About the application

Application number: 2025/62/93480/W	
What is the application for?:	Erection of 28 dwellings with associated landscaping and external works
Address of the site or building:	Land off Parkwood Road/Weavers Lane, Longwood, Huddersfield, HD3 4TT
Postcode:

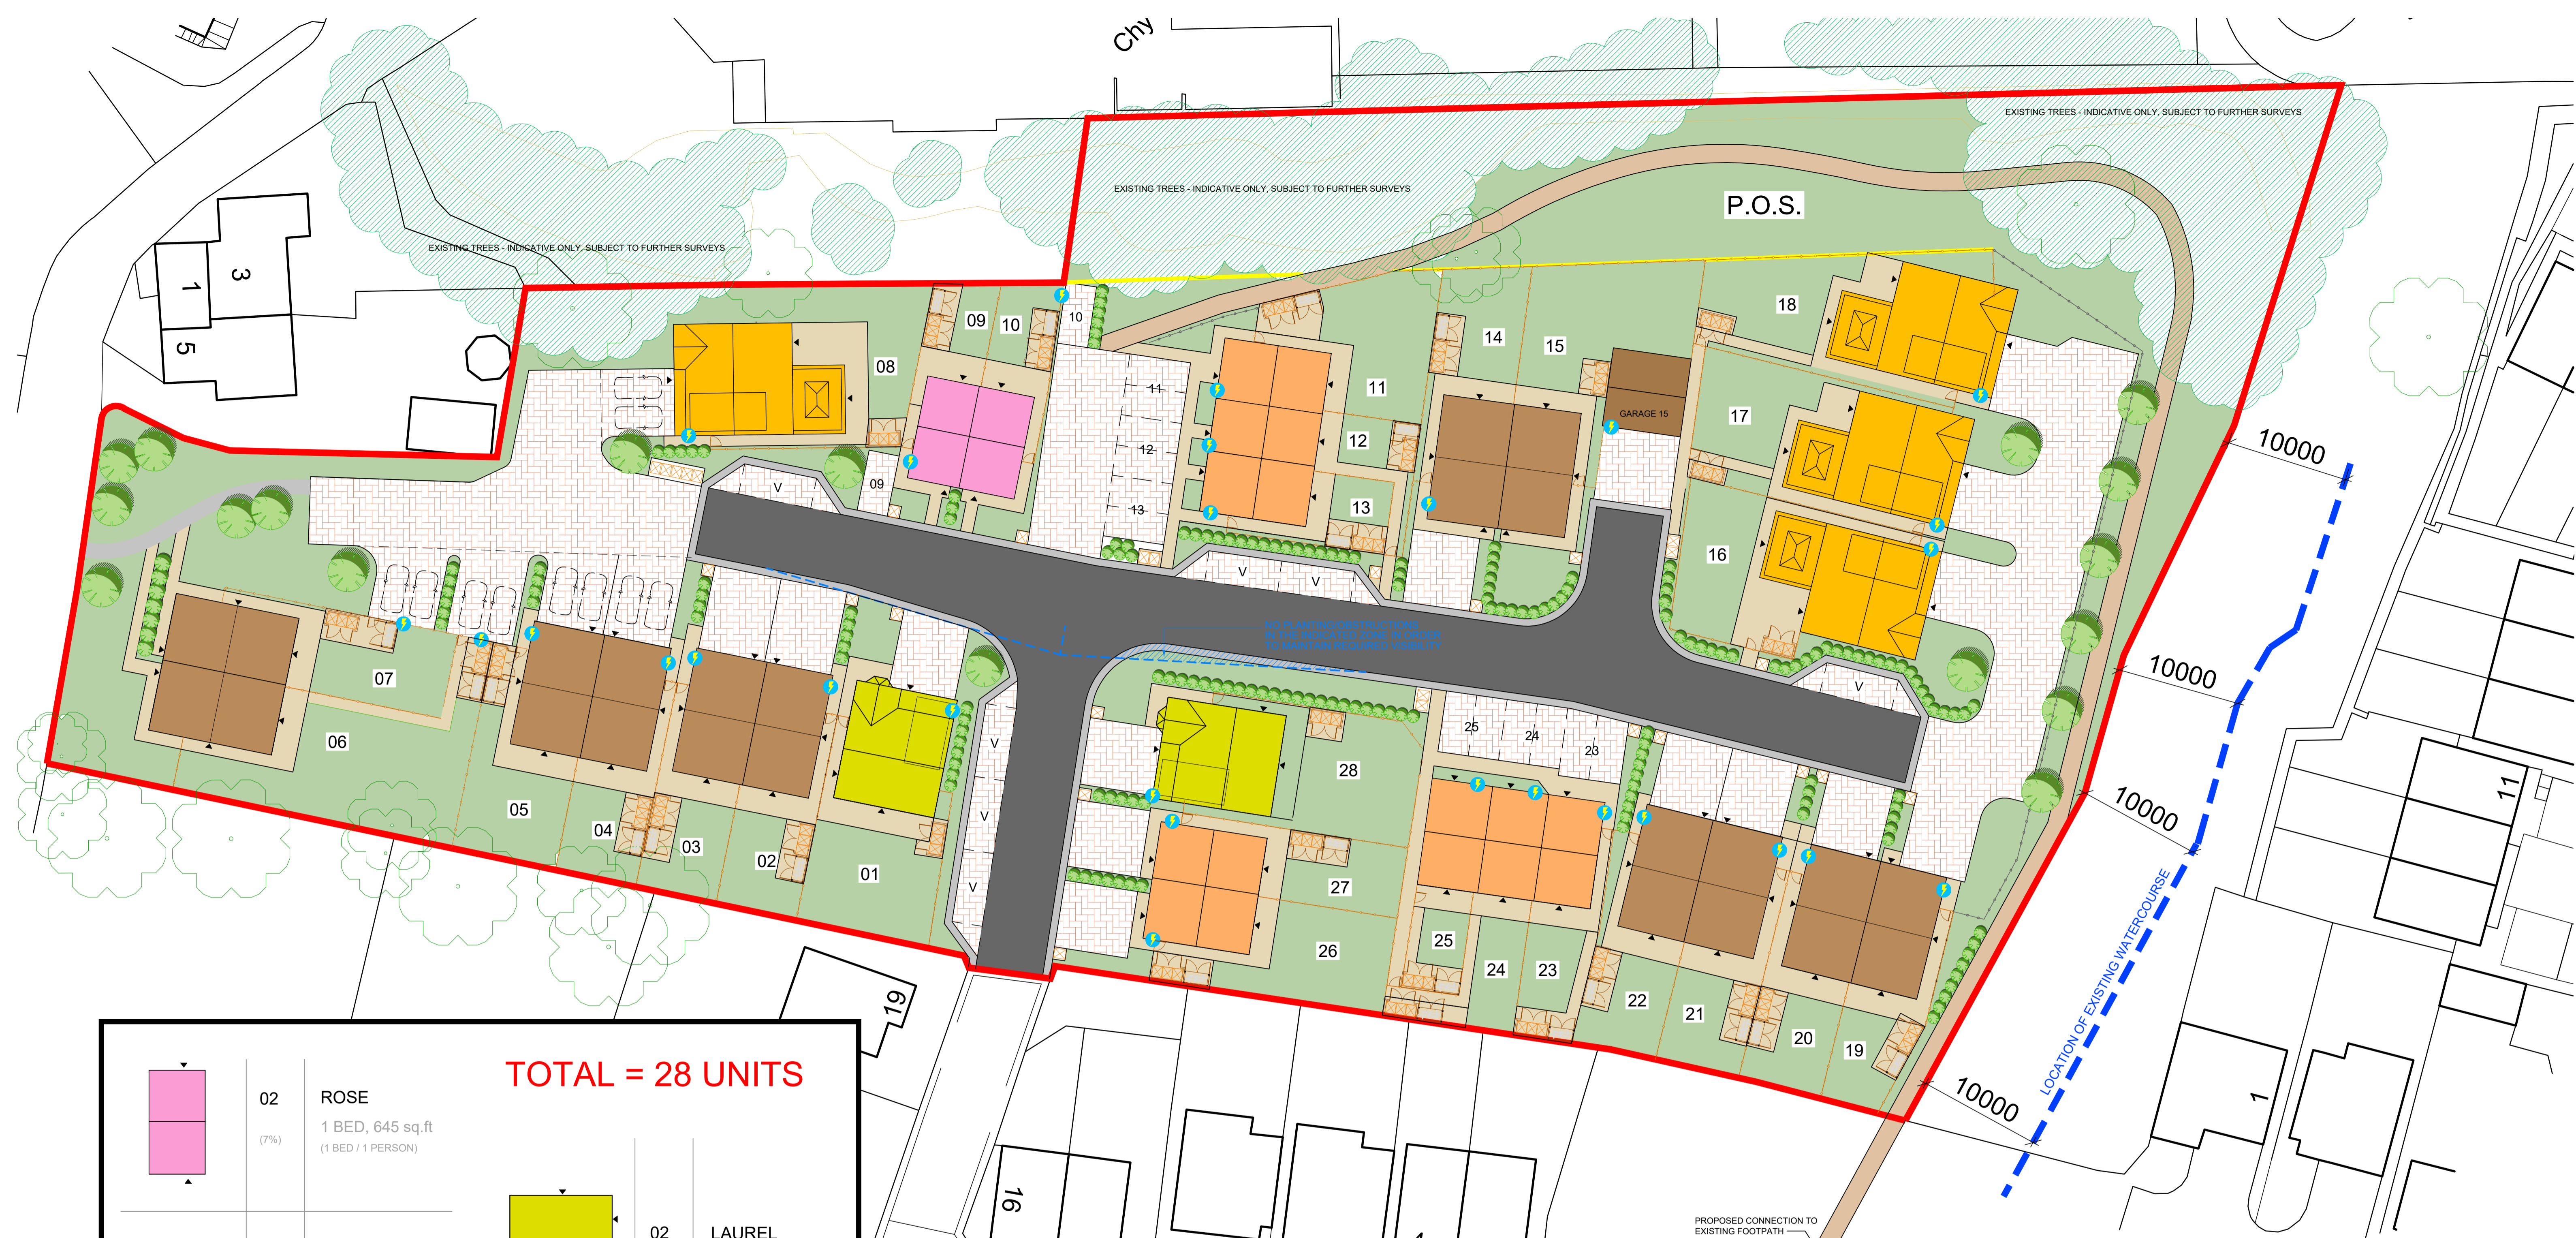
The plans also show a pedestrian link to a path that does not actually exist on the ground. This gives the impression of better walking connections than are really there and feels misleading.
